**From:** [Marlborough, Neil](#)  
**To:** [Wylfa Newydd](#)  
**Cc:** [Harding, Helen](#); [swyddfa@cyngortrefamlwch.co.uk](mailto:swyddfa@cyngortrefamlwch.co.uk)  
**Subject:** Wylfa Newydd Examination Deadline 2: NACP responses  
**Date:** 04 December 2018 20:15:38  
**Attachments:** [image001.png](#)  
[NACP Construction working hours.pdf](#)  
[NACP Local Opportunities.pdf](#)  
[NACP Residential Amenity.pdf](#)  
[NACP Suggested site visit locations .pdf](#)  
[NACP Temporary workers accommodation.pdf](#)  
[NACP Tourism and recreation.pdf](#)  
[NACP Traffic and Transport A5025 Treglele.pdf](#)  
[NACP Traffic and Transport crosscountry routes.pdf](#)  
[NACP Traffic and Transport other matters.pdf](#)

# Wylfa Newydd Nuclear Power Station: NACP Written Representation: Traffic and Transport, A5025 Treglele

Scale	AS SHOWN	Sheet Size	A1	Sheet(s)	1 of 1
Drawing Number	WN0902-HZDCO-OHW-DRG-00063				Rev
				2.0

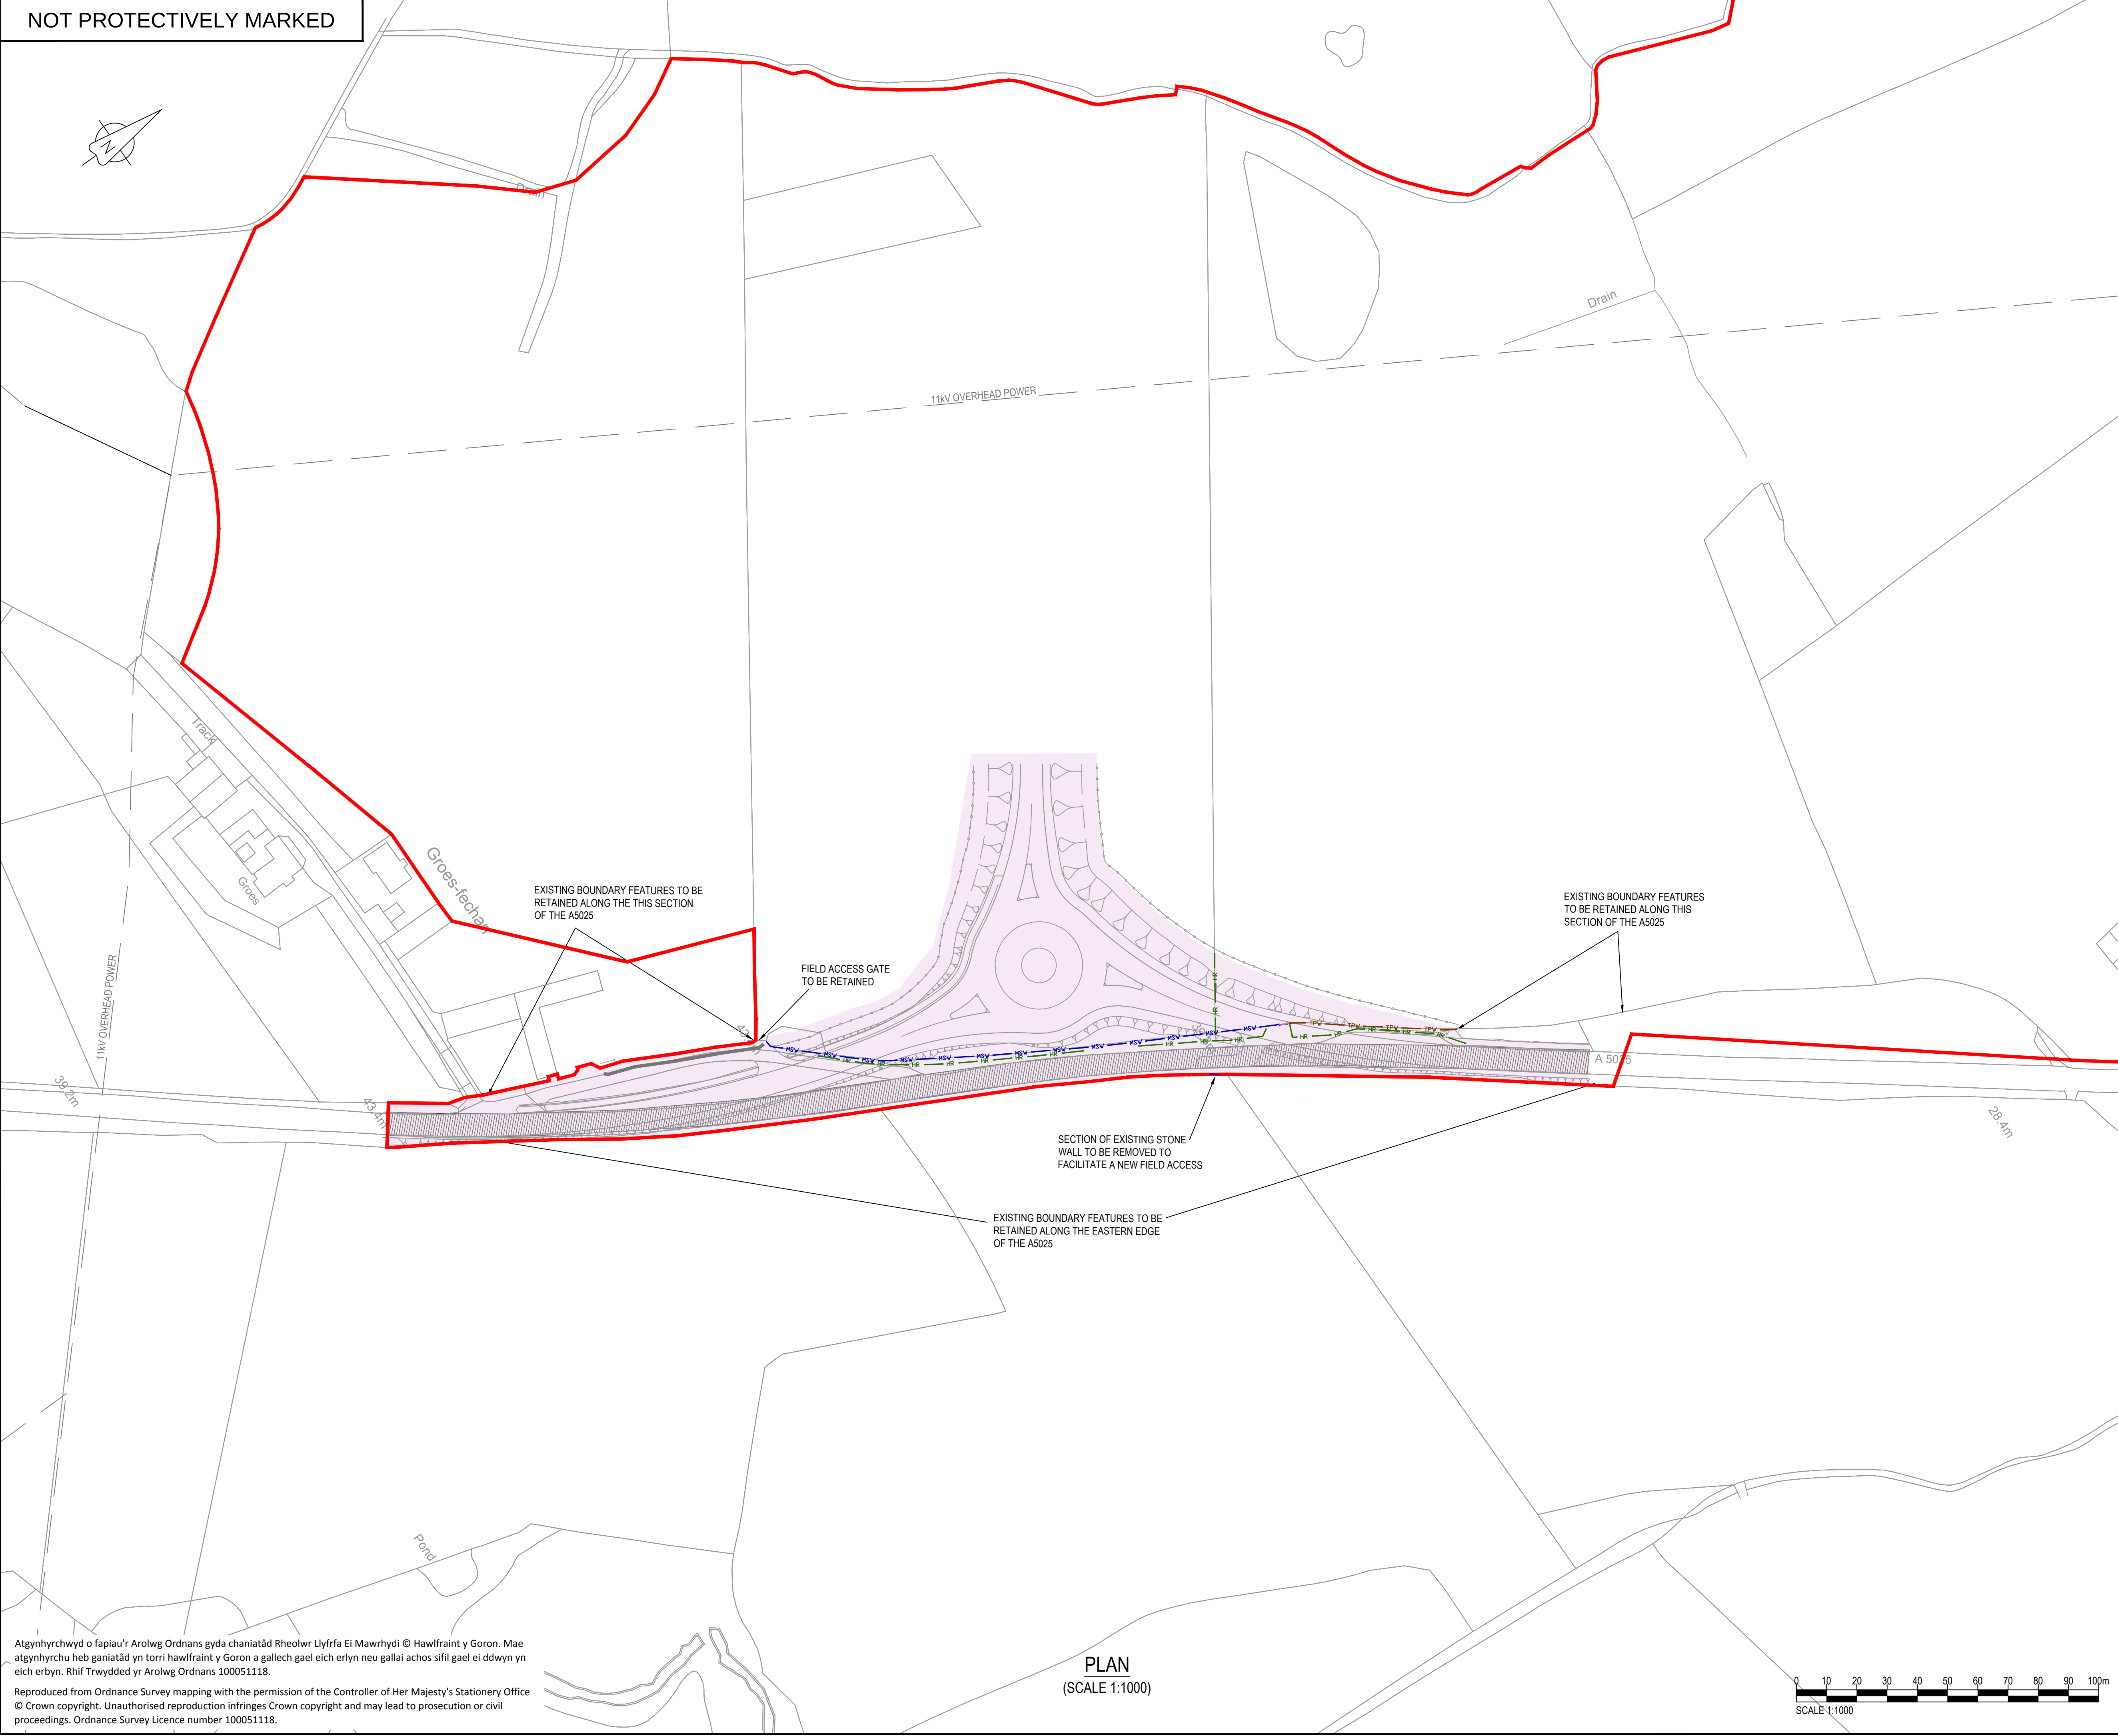
- 1.1.2 Within the application documentation, there are off-line highway improvements proposed on the main construction traffic route between Valley and the proposed roundabout access which lies some 900m south of Treglele. However, it is acknowledged by Horizon that the proposed roundabout access will not be constructed until 2020, therefore there will be a period of some 12 months when all construction traffic will pass through Treglele village on the A5025 to use the existing access to the site. Additionally, Horizon have also acknowledged that some construction traffic will route using the A5025 from Cemaes and so will pass through Treglele village once the proposed roundabout access has been constructed.

- 1.1.3 The NACP are concerned about the safety of pedestrians and all road users in Treglele as a result of the predicted increases in traffic flow.

- 3.2.1 Horizon considers that a pedestrian crossing and reduction in speed limit in this location is not required, but they have suggested that if issues of concern arise during the construction programme, these can be reported to the transport sub-group for consideration of further mitigation. This approach is of concern to the NACP, as the length of time taken to report and investigate any problem(s) followed by the design and construction of a solution(s) may well take longer than 12 months when traffic flows in this area will be at their highest.
- 3.2.2 There does appear to be an opportunity to provide further speed reductions, traffic calming measures and pedestrian crossing facilities within Tregele village. The NACP believe that these

options would mitigate the increase in traffic flow and provide pedestrians and all road users in the vicinity of Tregle with a safer more pleasant highway environment. This mitigation would also provide a legacy for the community beyond the construction of Wylfa Newydd and potentially mitigate similar effects that may arise during the operational phase.
